<b>Application Ref:</b>	3/2026/0284	 Ribble Valley Borough Council <a href="http://www.ribblevalley.gov.uk">www.ribblevalley.gov.uk</a>	
<b>Date Inspected:</b>	N/A		
<b>Officer:</b>	BT		
<b>DELEGATED ITEM FILE REPORT:</b>		<b>Decision</b>	<b>PERMISSION NOT REQUIRED</b>

<b>Development Description:</b>	Prior notification for the erection of two agricultural buildings for the storage of machinery, equipment and agricultural materials.
<b>Site Address/Location:</b>	Lower Gazegill Farm, Cross Hill Lane, Rimington, BB7 4EE.

6 Ground Proposed Shippon 1
1 : 50

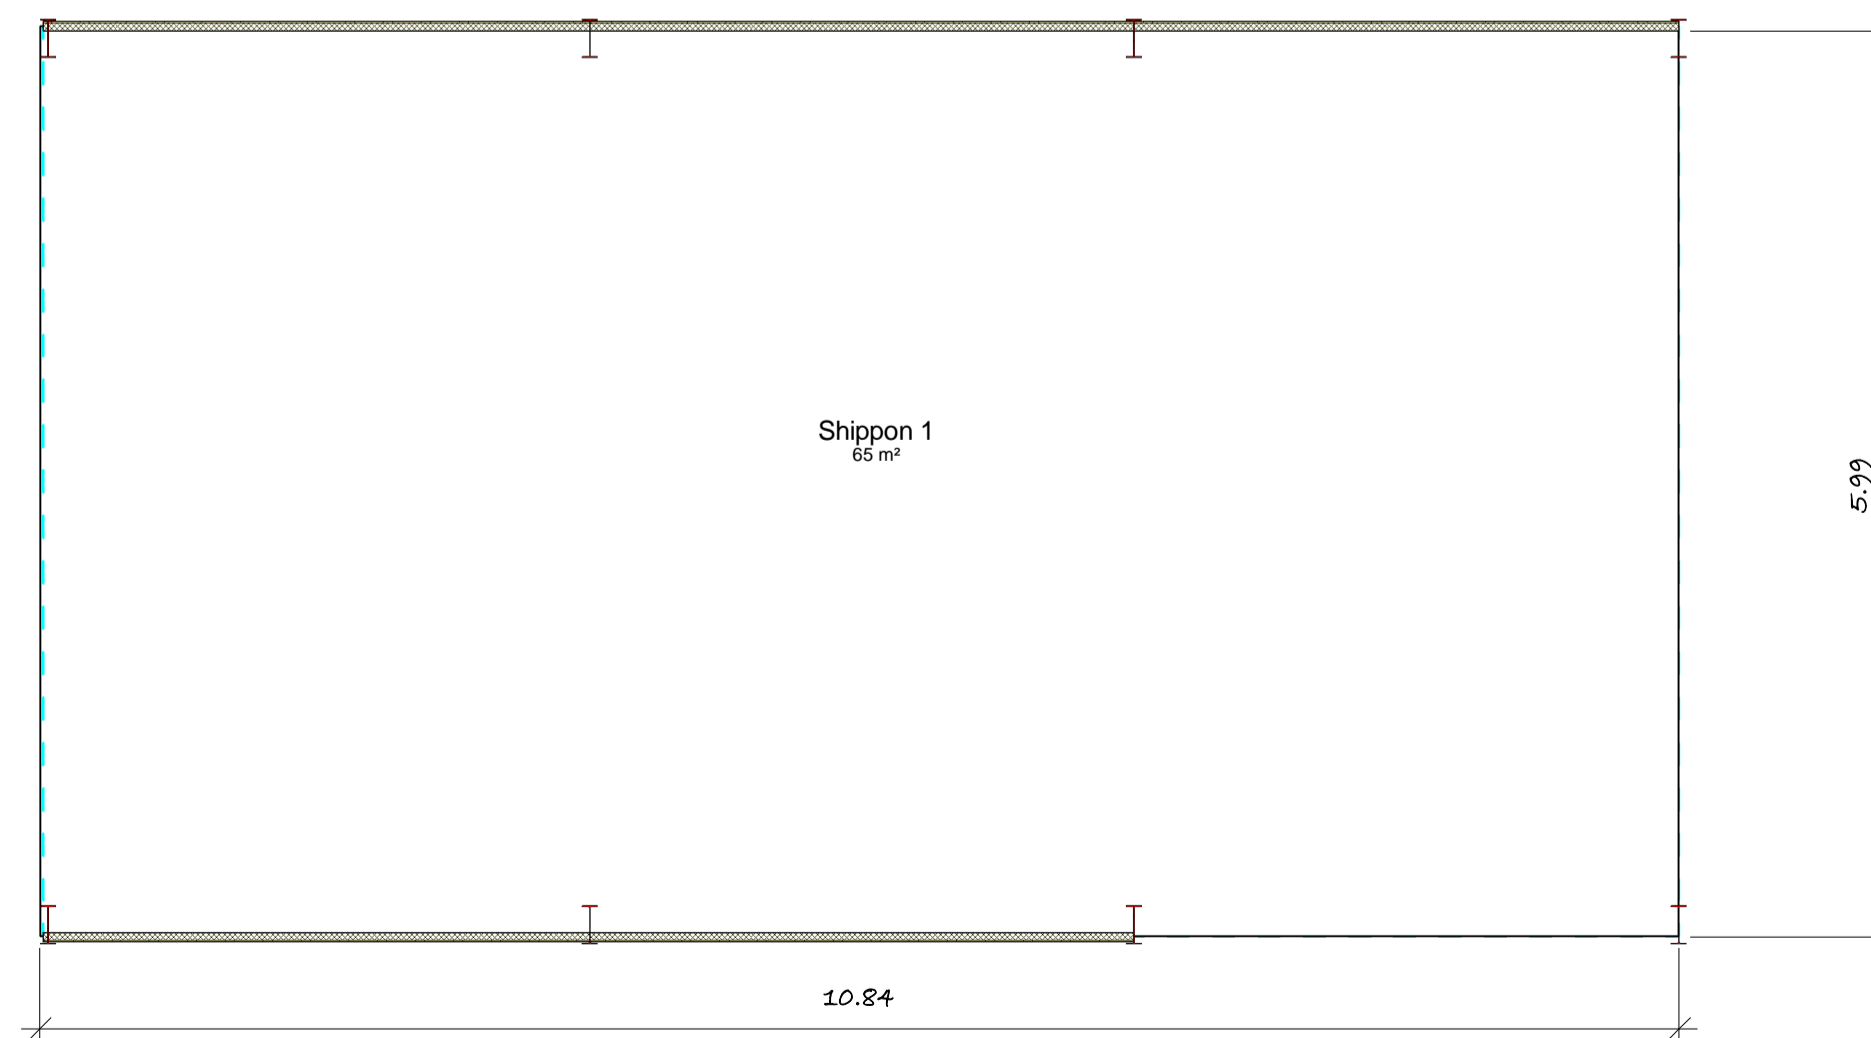
**The cumulative ground floor area of the proposed agricultural buildings would measure 262m<sup>2</sup>, within the above threshold limit**

Drawing; Shippon 2

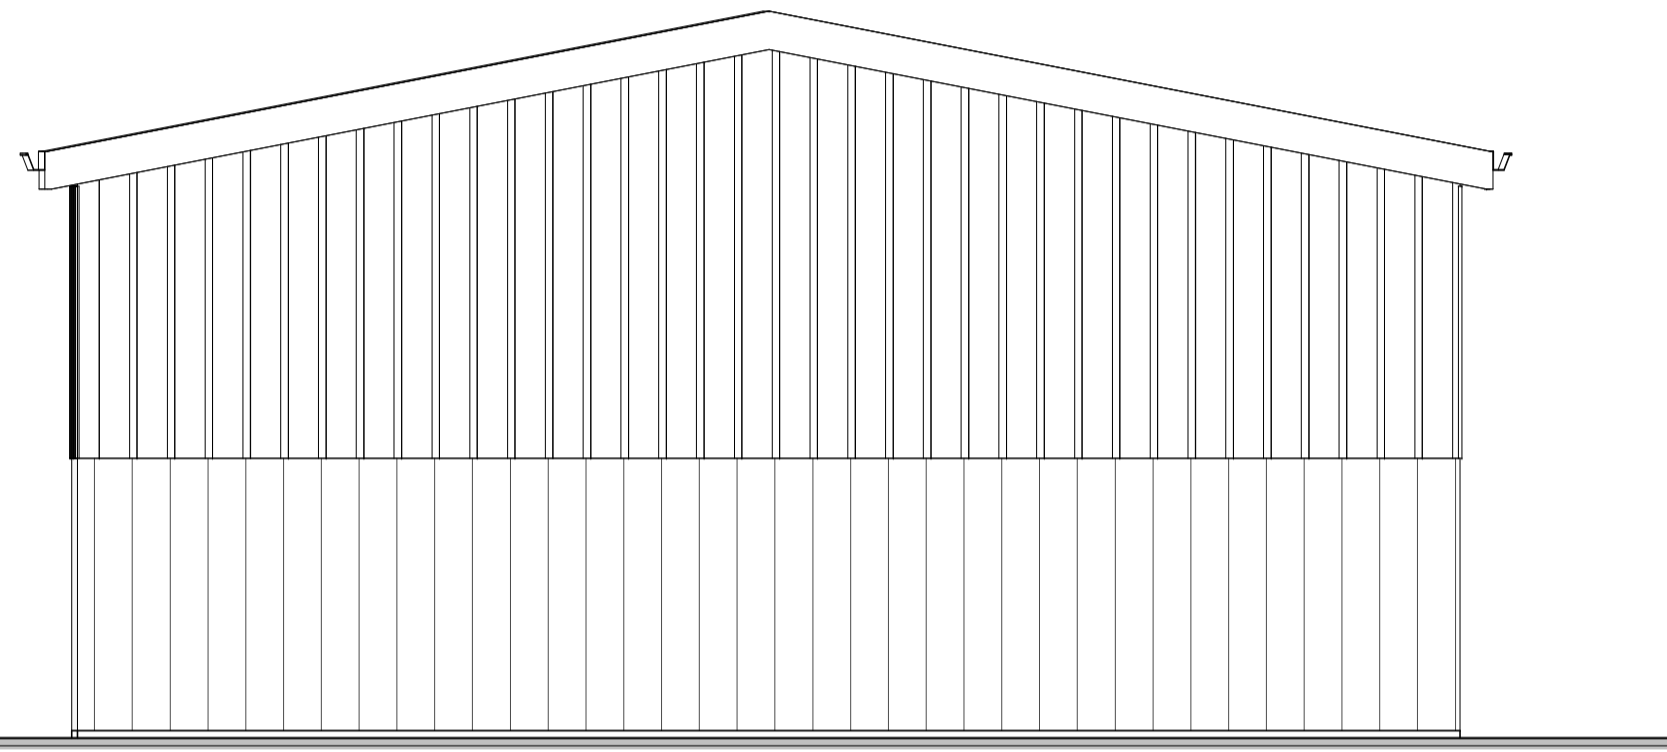
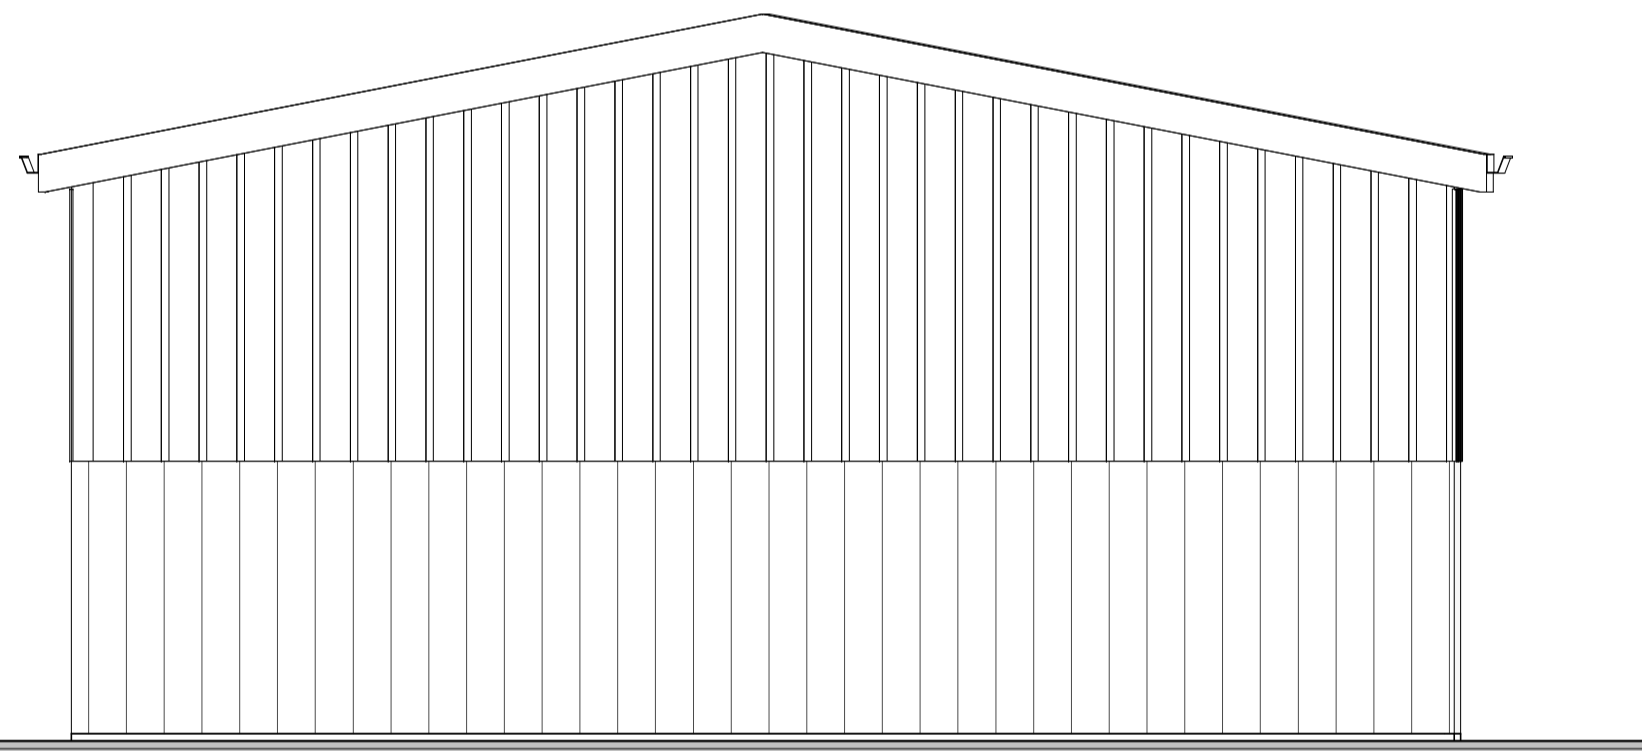
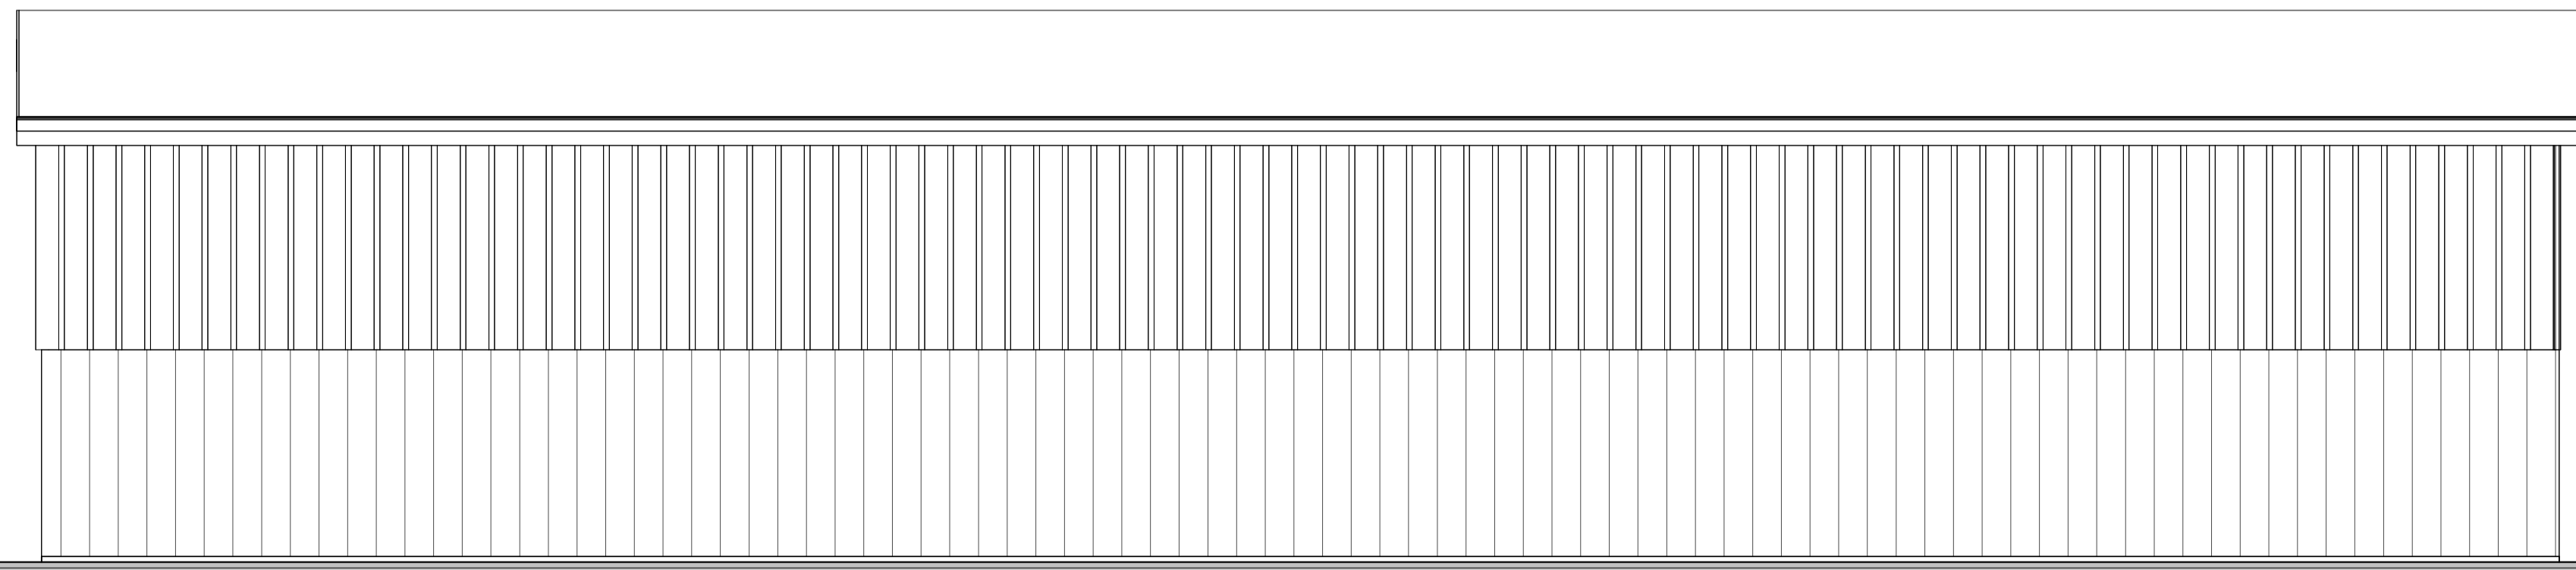
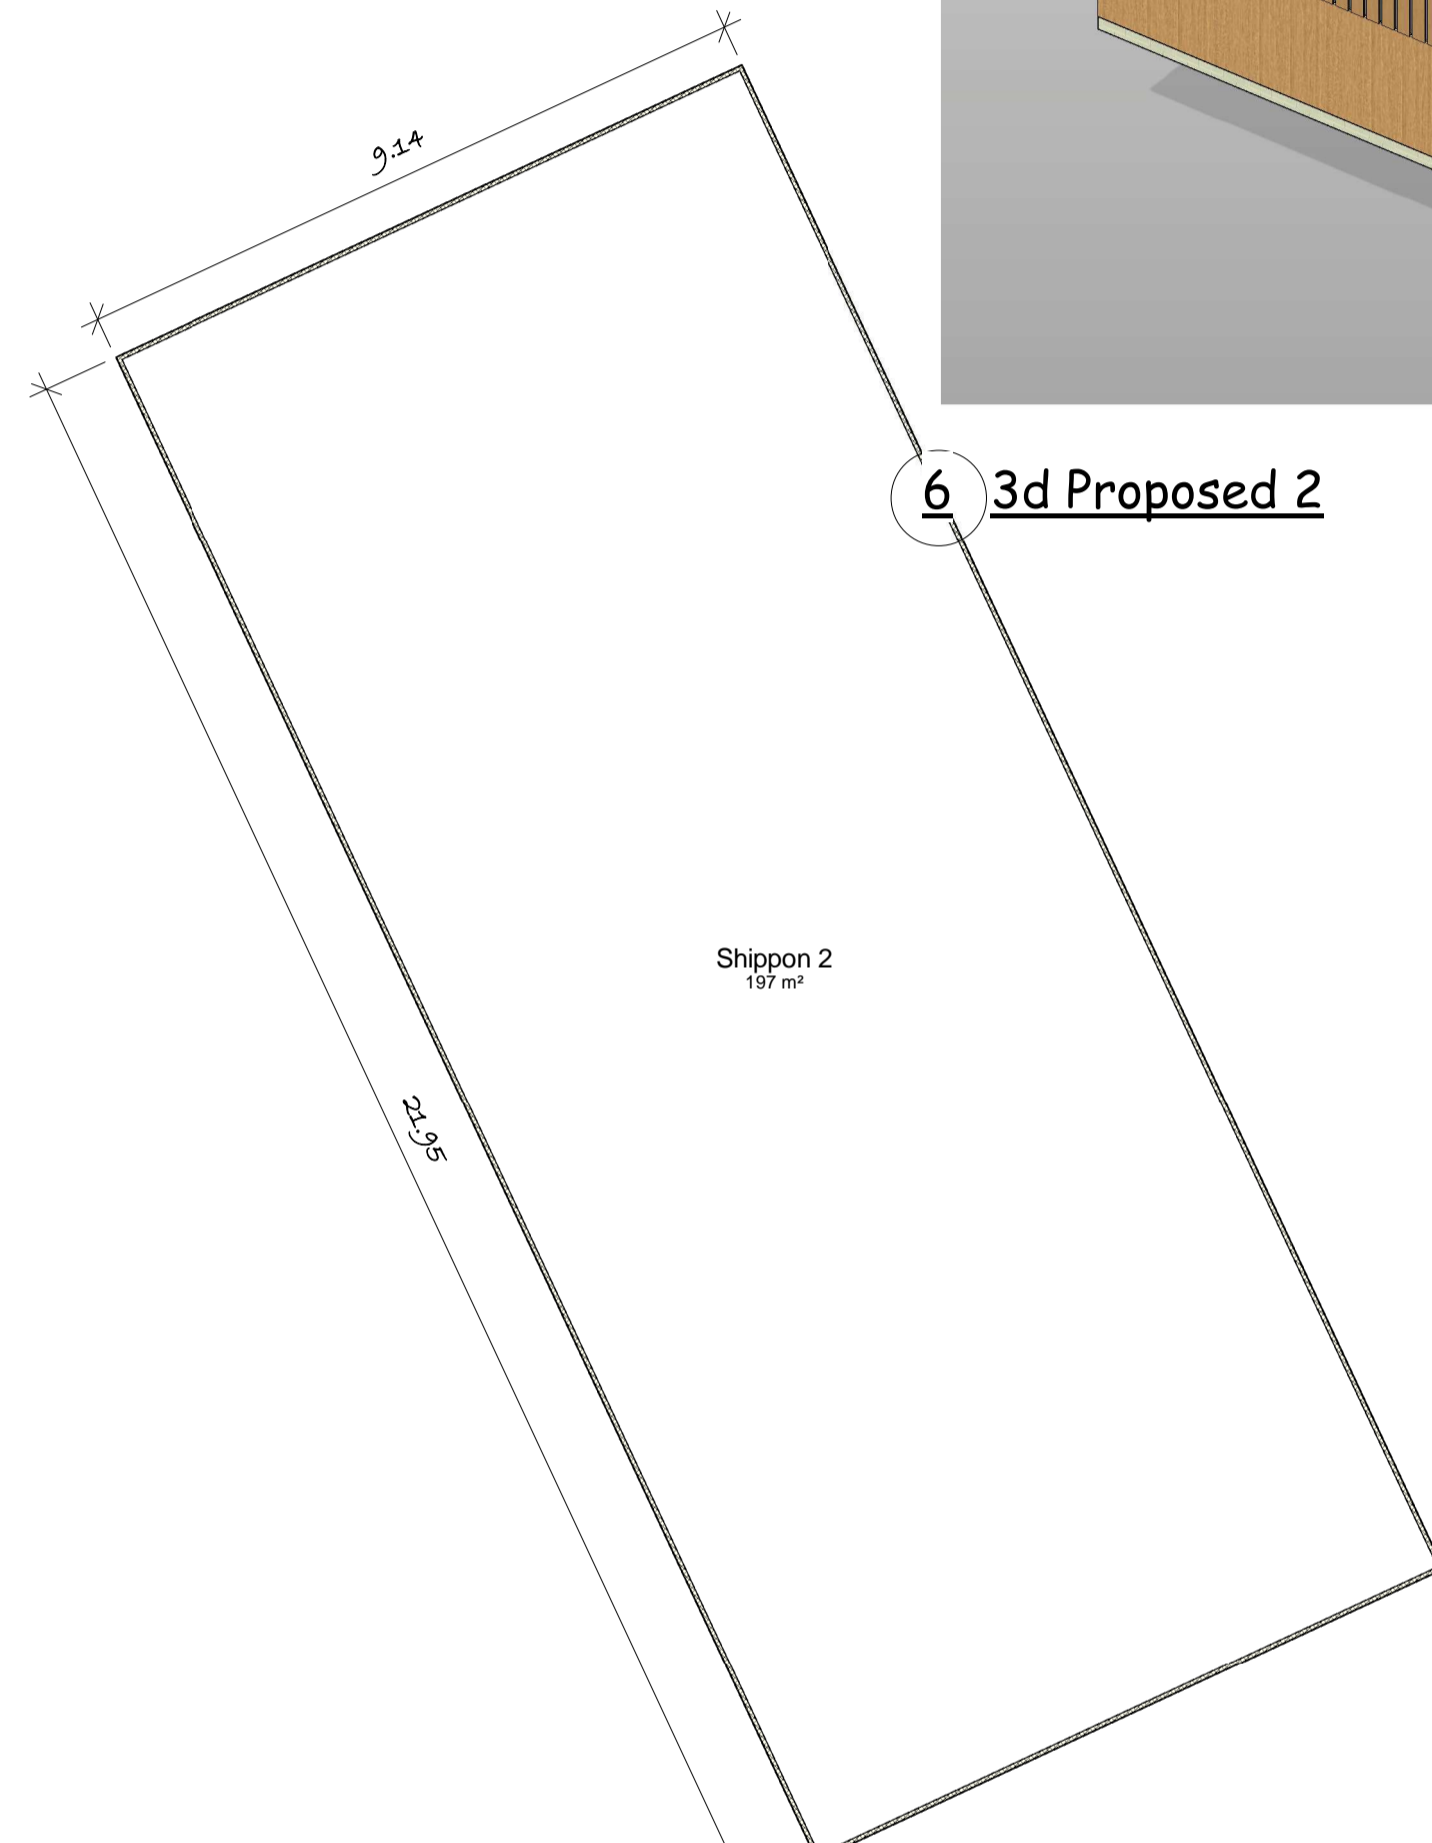
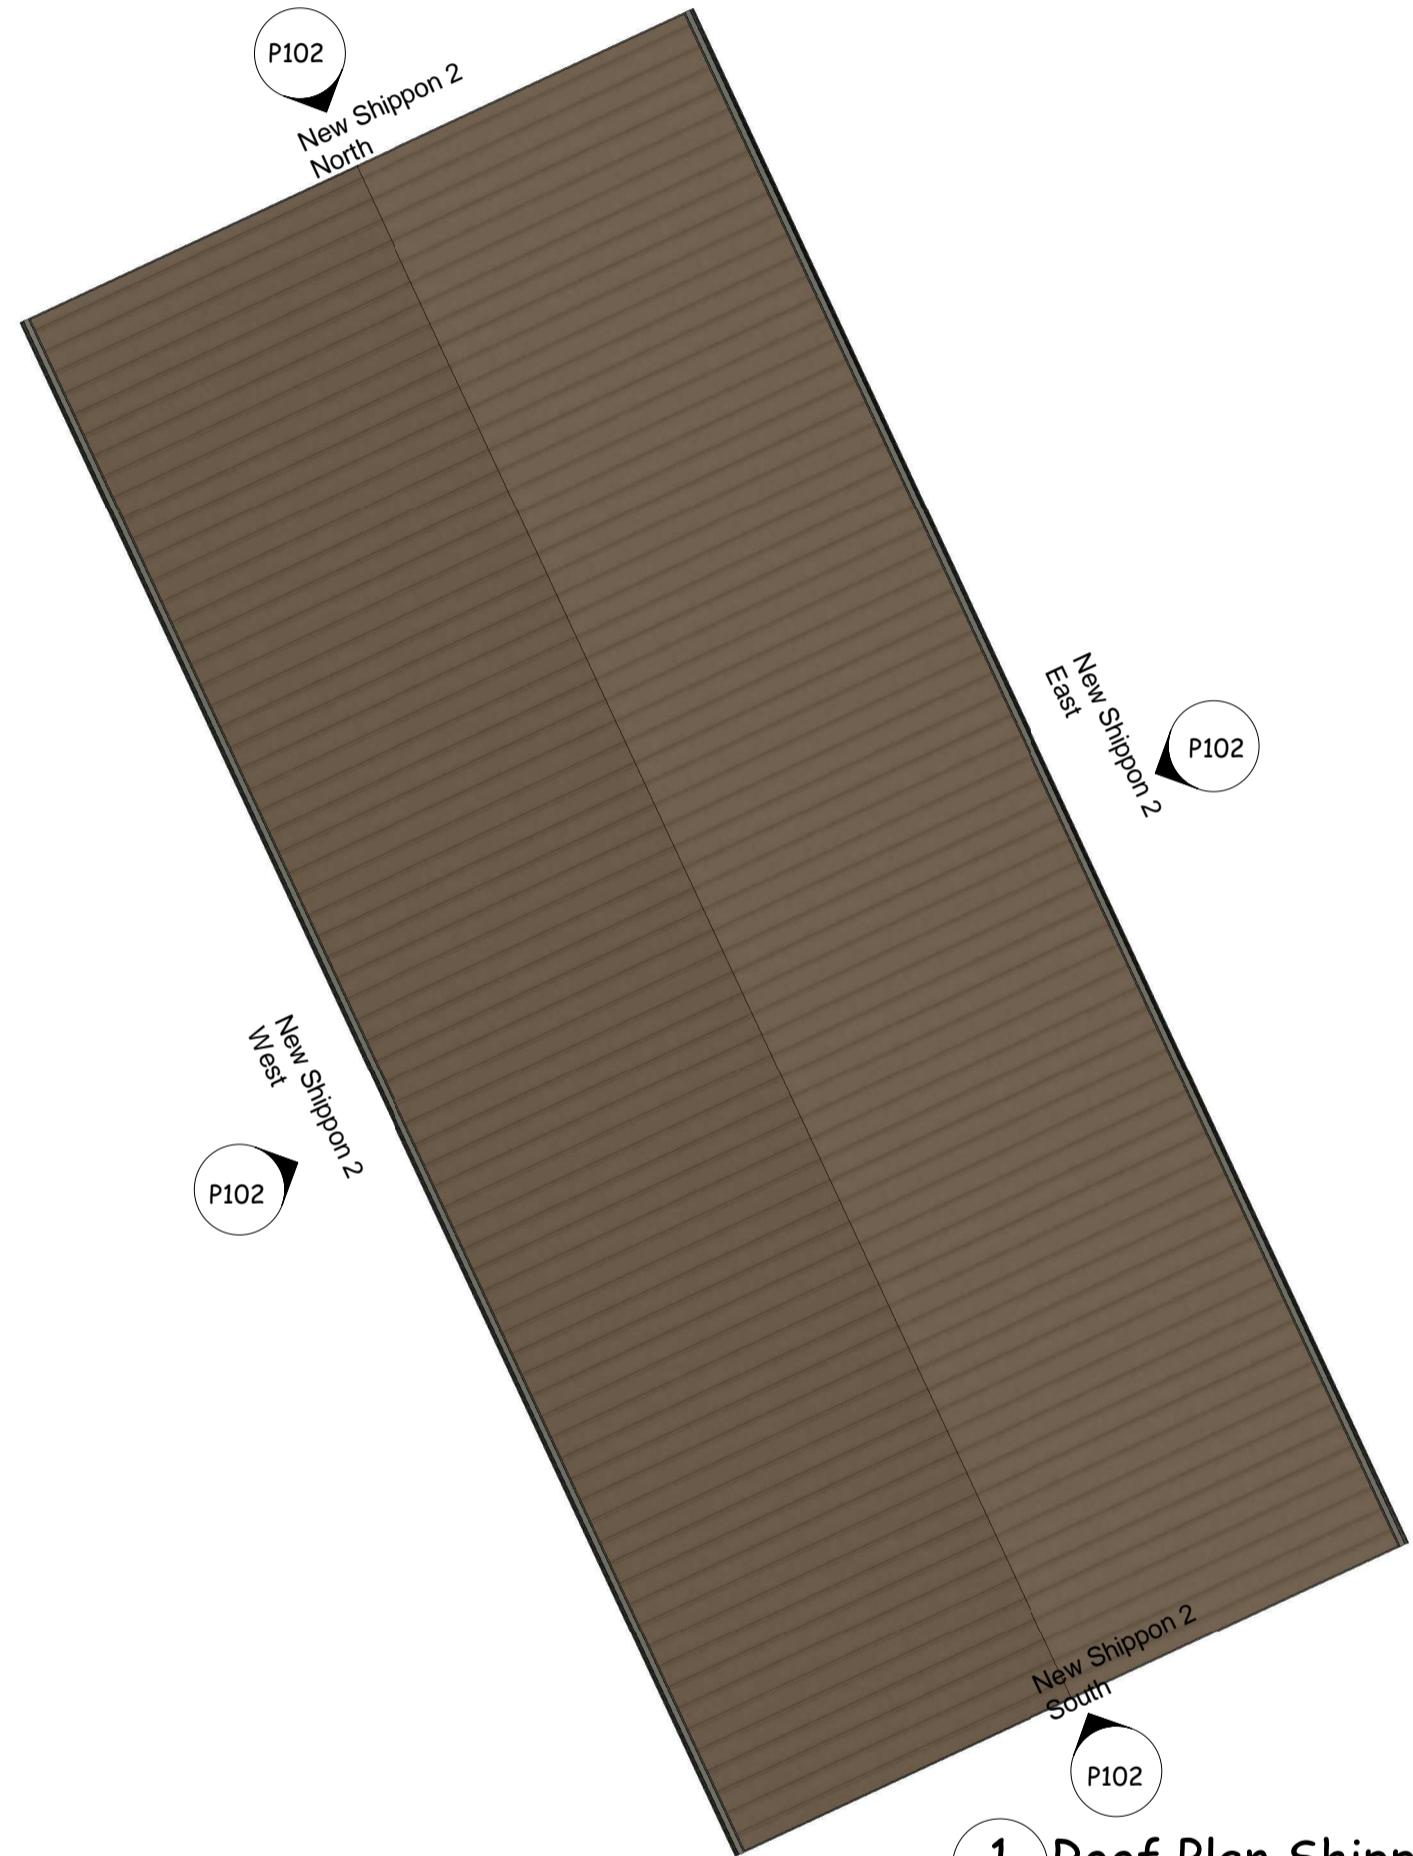
**The highest part of the proposed agricultural buildings would be 4.2 and 4.7 metres**

The proposed agricultural buildings would comprise a portal framed design detailed in timber cladding and dark green profiled roof sheets, all of which are materials commonly used in the construction of modern agricultural buildings and which would also match the external appearance of the existing buildings within the farmstead. As such, the external appearance of the buildings would be in keeping with the existing built form within the application site and rural vernacular of agricultural buildings within the locality. In addition, the proposed buildings would comprise a similar size to the existing shippon buildings within the farmstead with respect to their footprint and would therefore not read as an over dominant additions to the application site. Accordingly, it is not considered that the proposed development would be harmful to the visual amenities of the immediate area or wider landscape.
